City of Albuquerque
Stormwater Construction Site
Inspection Report

Project Name and Location	O'Reilly Auto Parts 8001 Ventura St NE		
Site Contact Name & Agency	Steve Haglan Hutton Construction	ESC File No. NPDES ID No.	020 E0706 NMP 1001 E6
Date of Inspection	1-3-19	Start/End Time	11:10/11:15
COA Inspector Name	Curtis Cherne, Stormwater Quality		
Describe Present Phase of Construction	Stabilized		
Type of Inspection:	<input checked="" type="radio"/> Regular • During storm event • Post-storm event (> 0.25 inch) • 311 / Complaint Response • Follow-Up

Robert,
Good afternoon.
I went by your project at 8001 Ventura this morning.
The project was just getting started.
The following issues were observed:

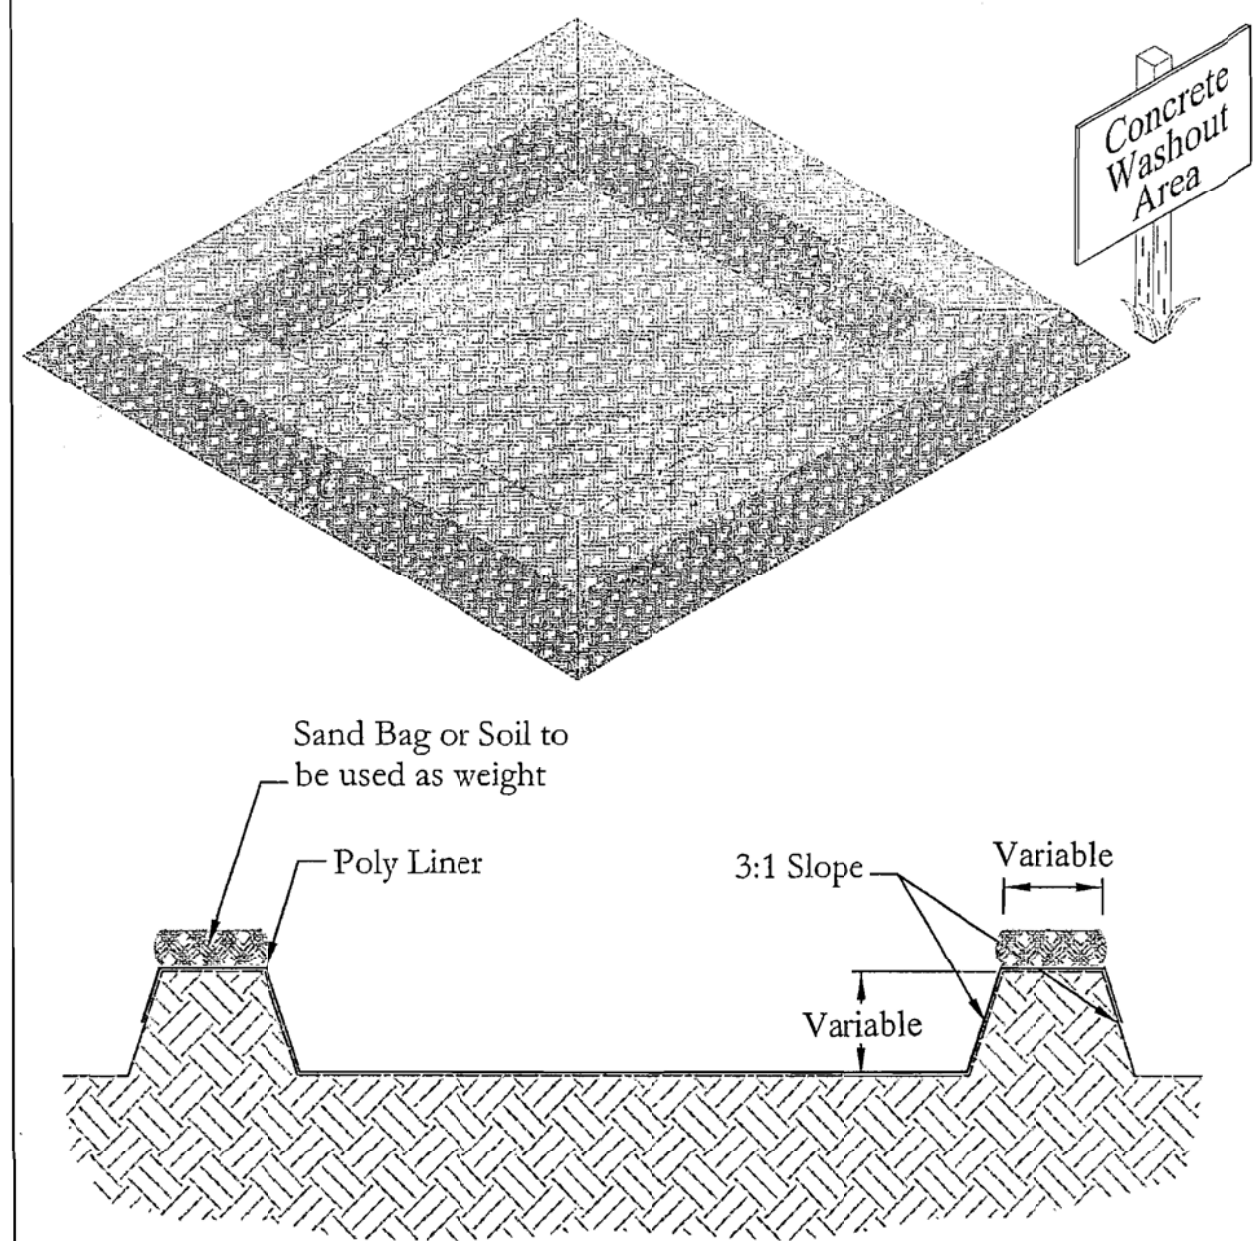
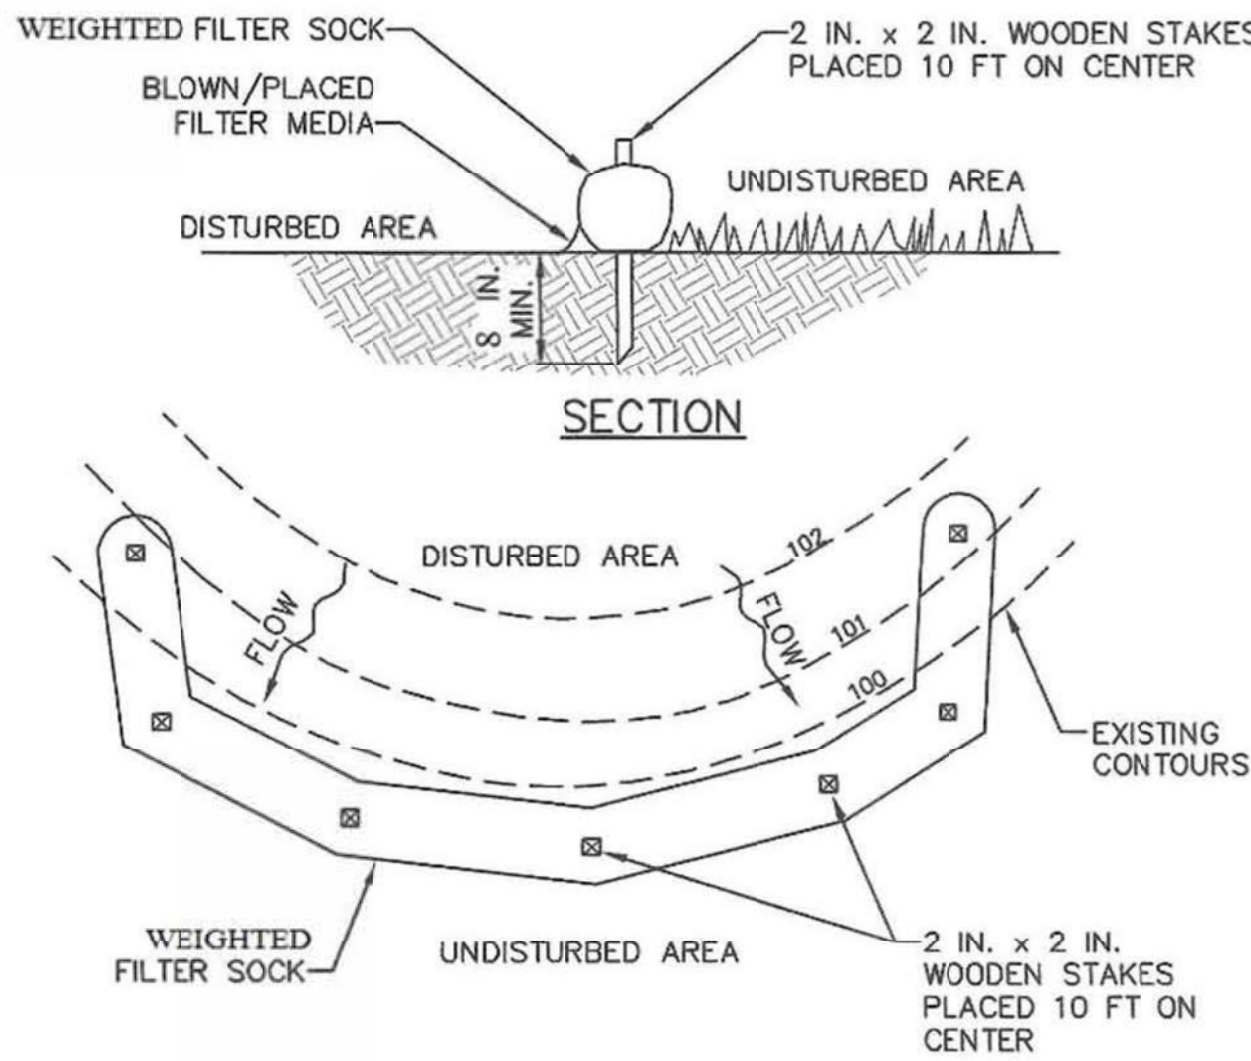
2.2.4	Minimize sediment track-out	• Yes • No	<input checked="" type="radio"/> Yes • No	no vehicle tracking control
2.2.5	Manage stockpiles	• Yes • No	• Yes • No

Please see the attached correction photos for the O'Reilly's at 8001 Ventura St Albuquerque, NM. If you will, please give me a call on my cell in regard to the track out pad. This is the only item on the list that has not been corrected. Our plans do not show the track out pad and the site is very small, making it difficult to squeeze in. We are willing to make any efforts though to help accommodate this item.

Entrance / Track-Out	no track-out pad
Sediment Controls / Silt Fence, Inlet Protection, Wattles, etc.	gap in filter sock NW corner sediment leaving site dirt pile outside BMP gap in filter sock SW corner and dirt pile is too high sediment in south drive aisle, no sediment BMP at Pond
Inspection Reports

*talked to Michael 7-31-18
told him ok to Smith Bros to
sweeping.
Also - 2 goals - dirt from leaving
site in SW corner
and
prevent Walgreens customer from
traveling out into venture*
